From: Travis Lythall
Sent: Monday, 7 December 2020 5:42 PM
To: 'Prity Cleary'
Cc: 'Suzie Hendry'; 'Gayatri Sawe'; 'Vicki van Dijk'
Subject: RE: SSD 9472 - Sikh Grammar School - Request for Additional information
Attachments: RFI Request for Additional Information_04122020_035605_.pdf; PT18022r02 - Proposed Sikh Grammar School Rouse Hill CTMP_Final_V3a.pdf; PT18022DA01 Model (1).pdf

In relation to the attached RFI, please see below comprising formal comments provided by Positive Traffic. As a general note, Positive Traffic confirm that locations of trucks and vehicle movements by stages would be subject to a separate Construction Traffic Management Plan (CTMP). A Preliminary CTMP was previously prepared (and submitted); however, detailed information cannot be provided until the Detailed Design phase prior to the issue of the relevant Construction Certificate. Notwithstanding, the comments are noted as follows:

© PMDL pmdl.com.au | Project 2757 | Scale 1:750@A3 | Date MAR 2019 | Dwg DA134

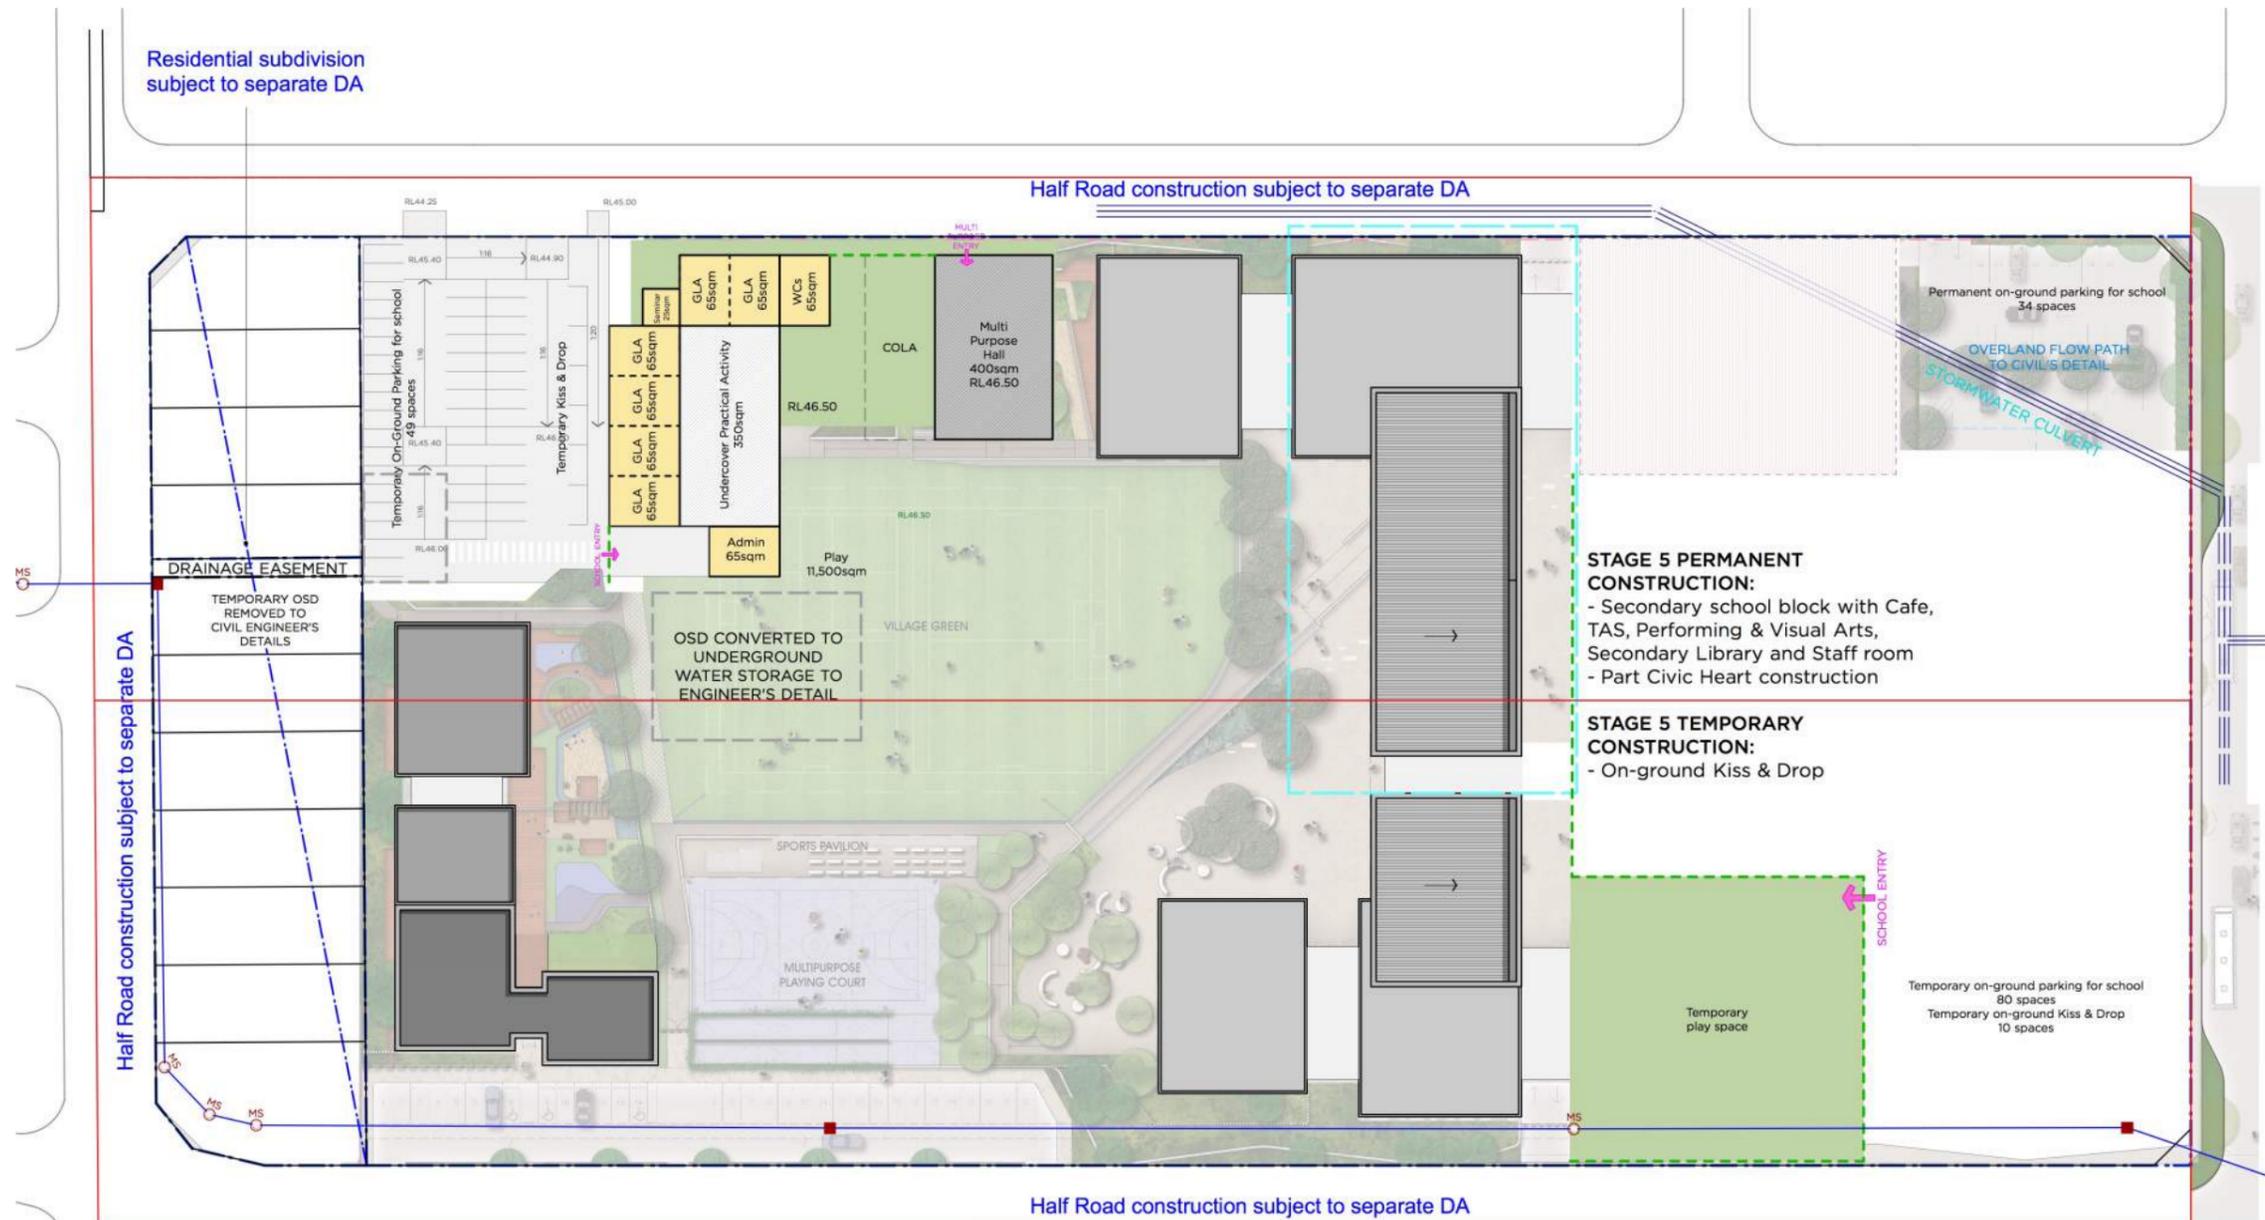
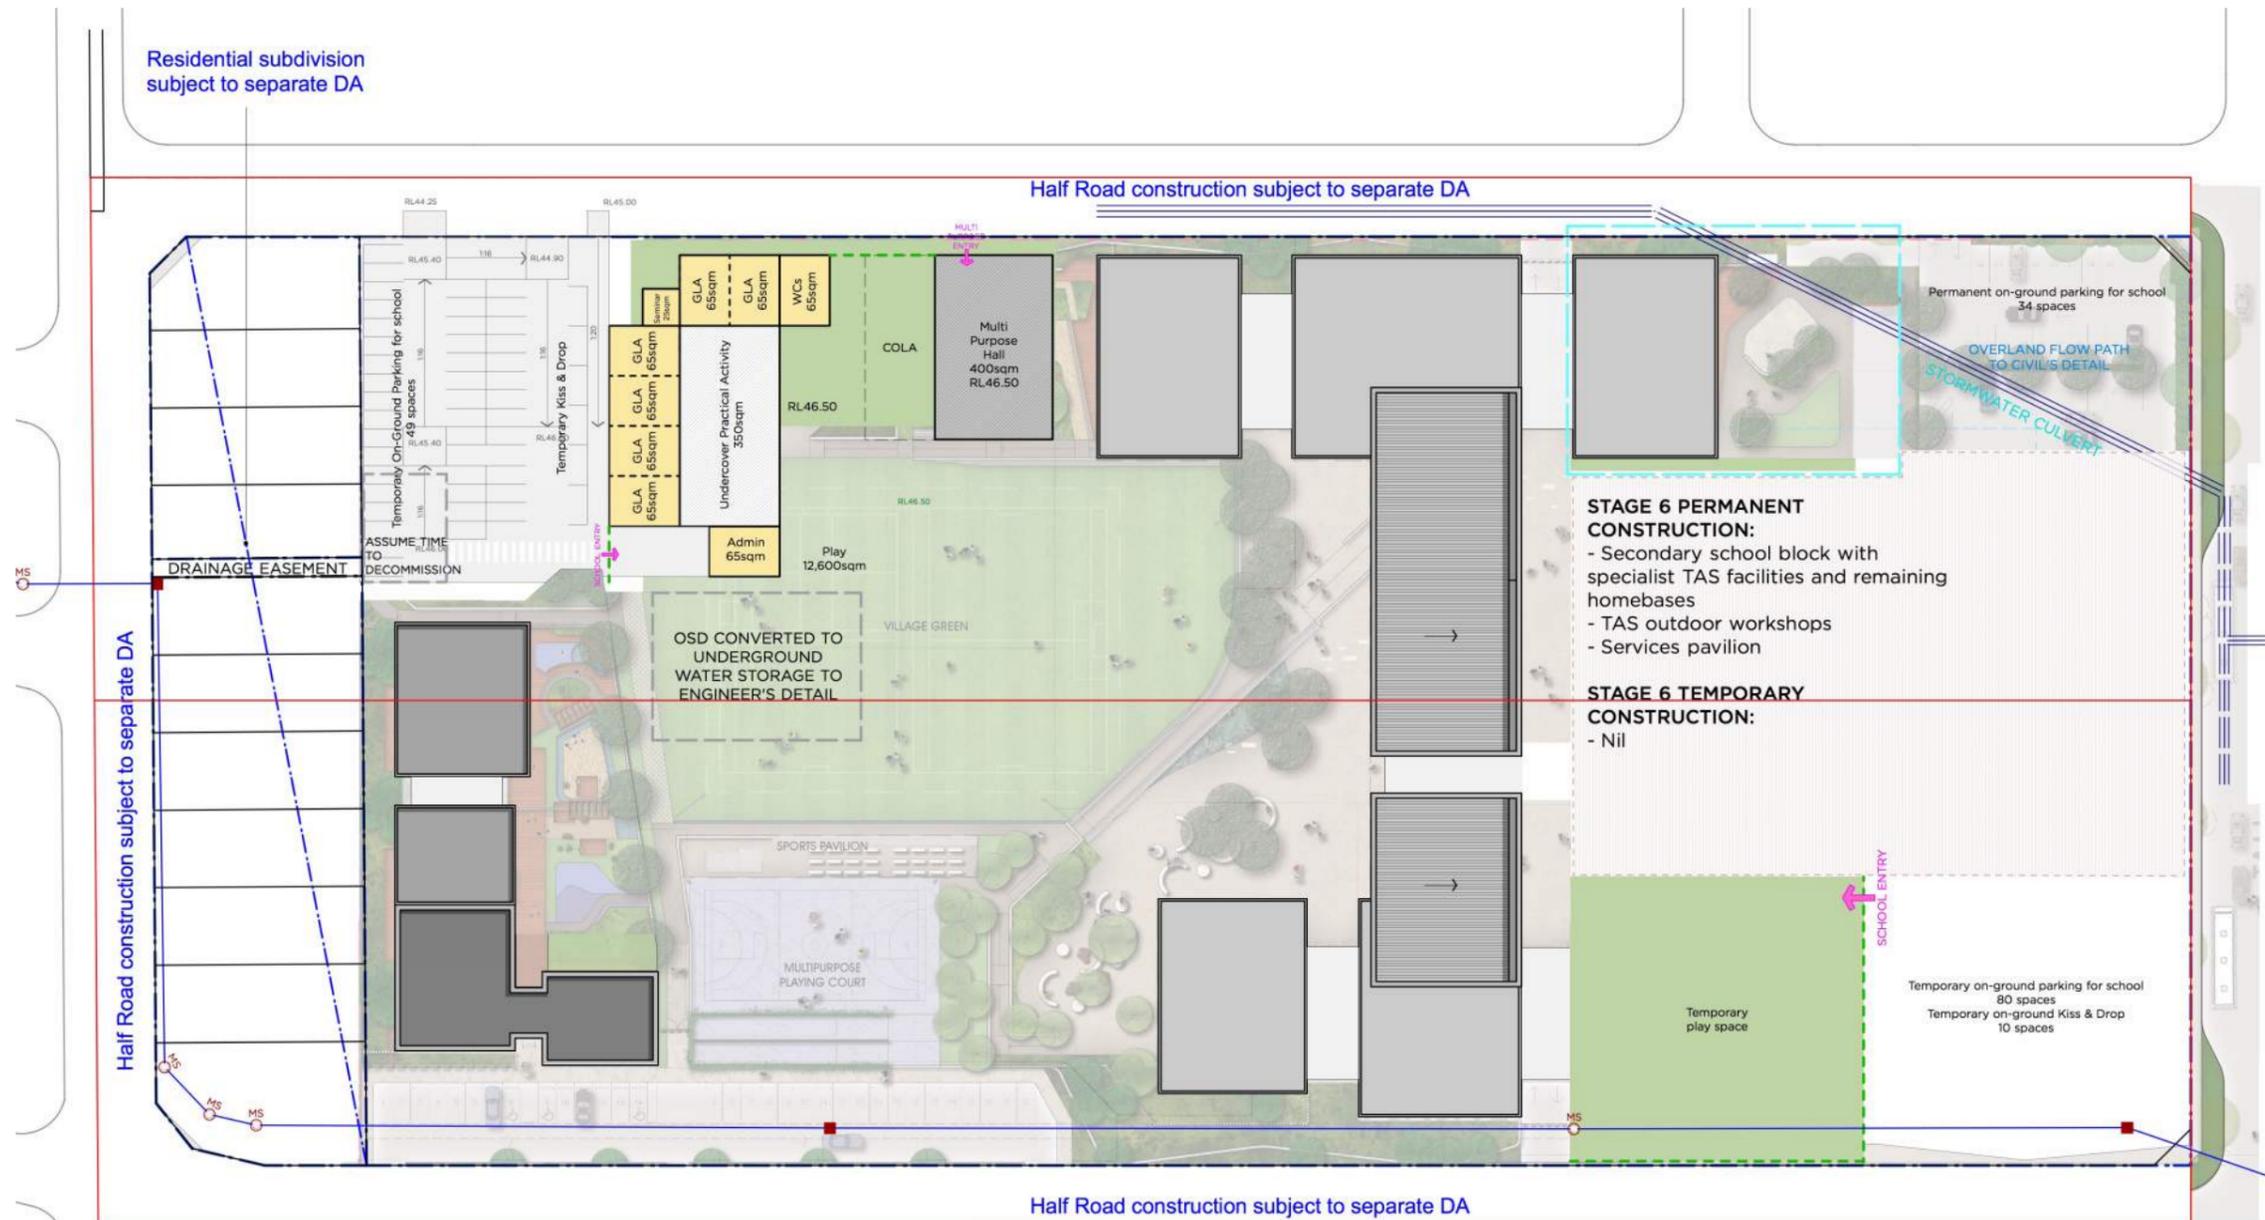
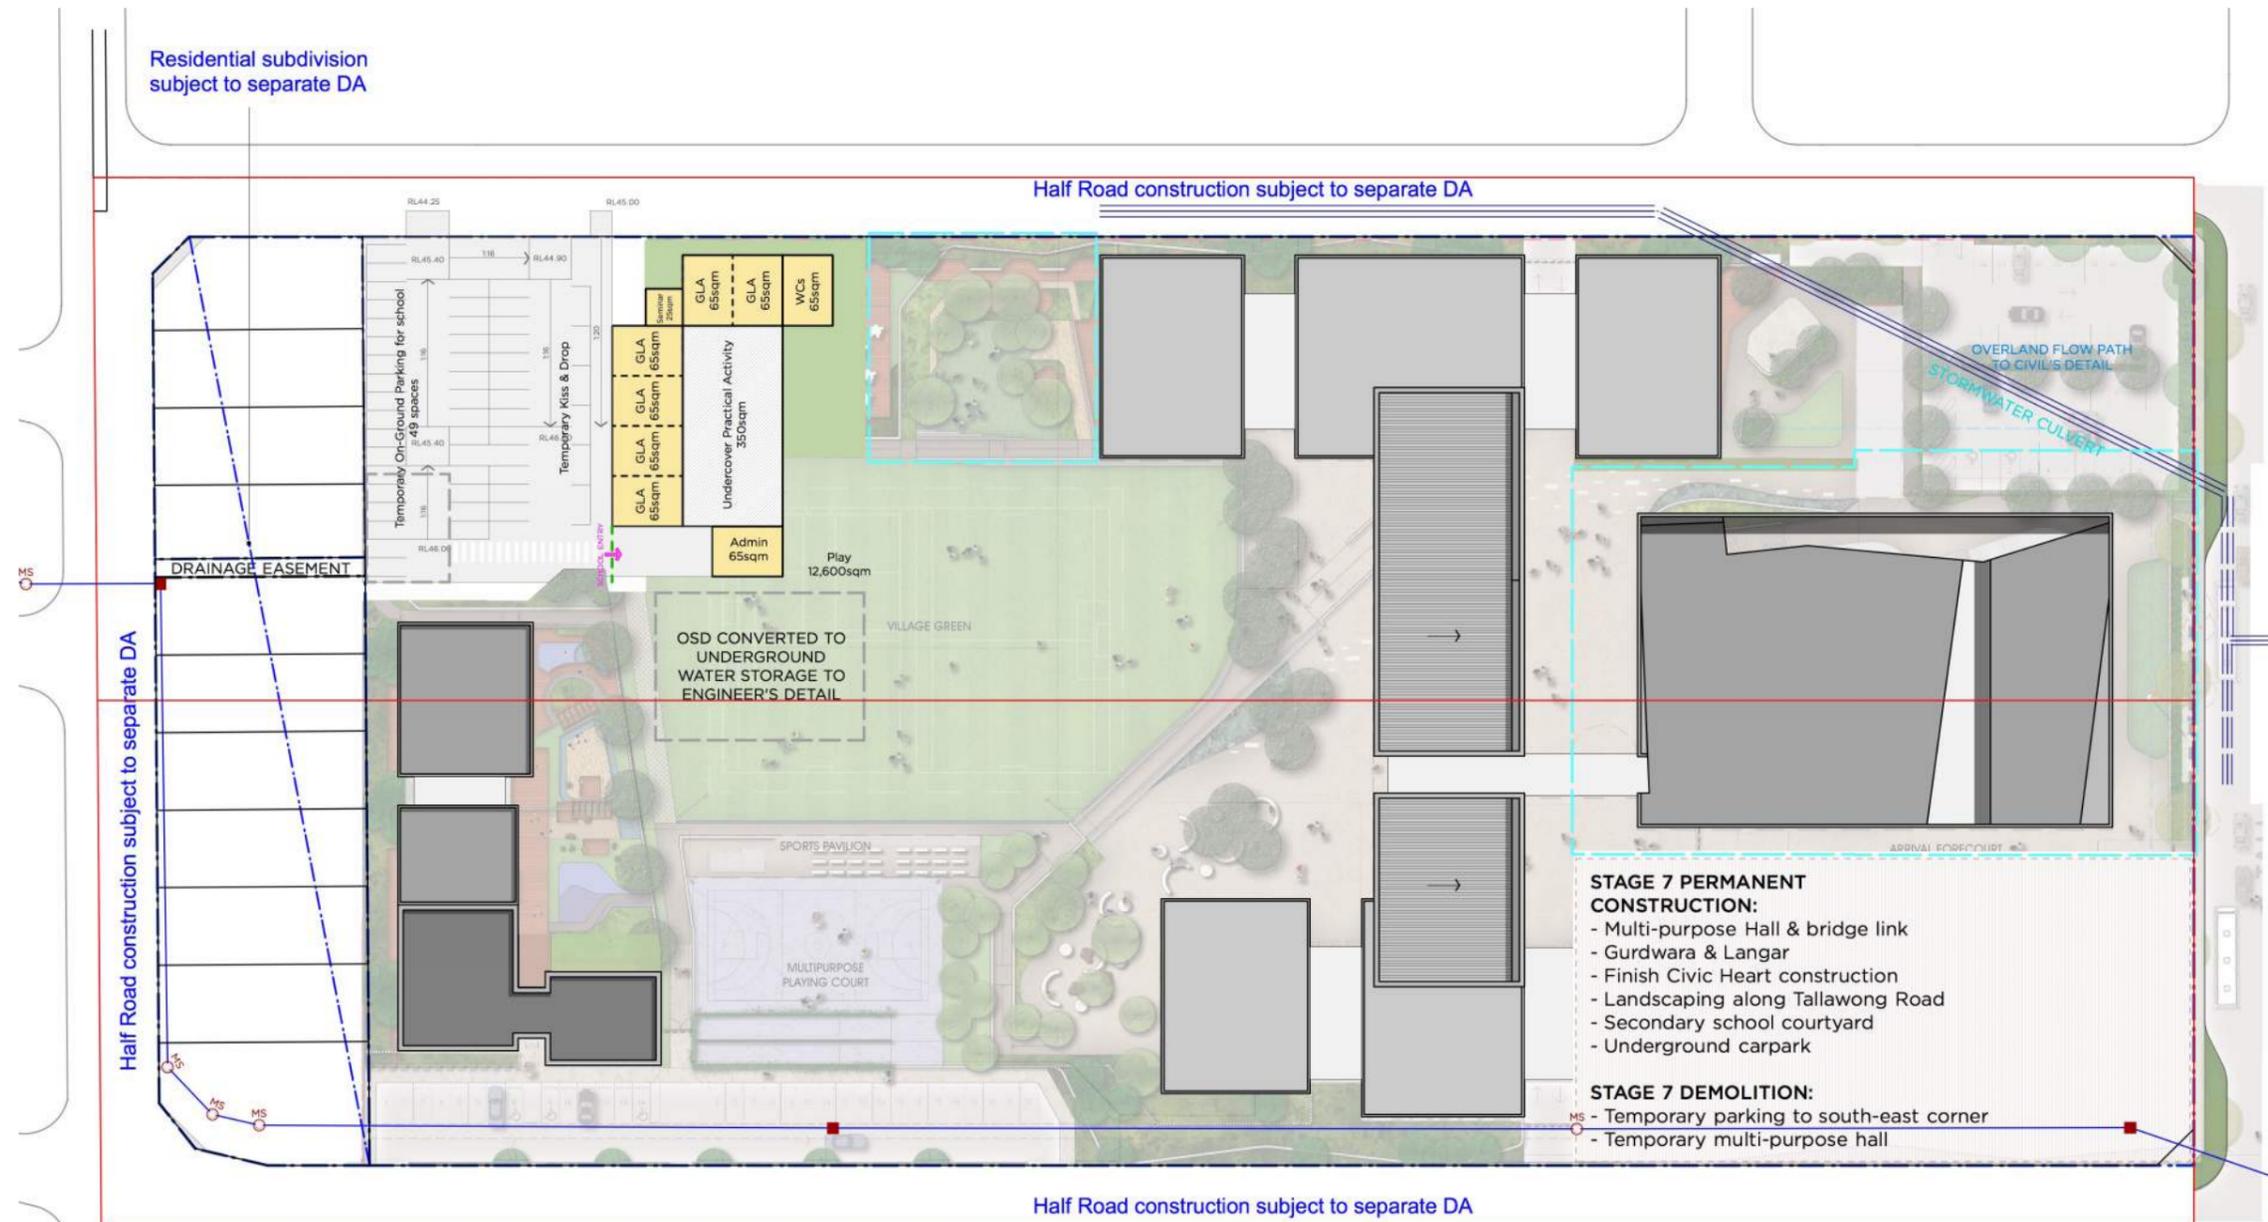
It is noted that throughout all the submitted documents (EIS report, RTS report and supplementary RTS) the construction timeframe is stated as 10 years. However, the staging plans in the Architectural Design Report

(pages 59- 69 in Appendix 4 of the RTS) reflects 24-year timeframe. These staging plans are to be revised to reflect a 10-year construction timeframe so it's consistent with the submitted documents.

It is noted, that the EIS reported on a 10-year construction program as a result of the staged construction; however, it is confirmed that the ultimate built form of the Site would not be realised until a 24-year timeframe. The staging plans are to remain as submitted.
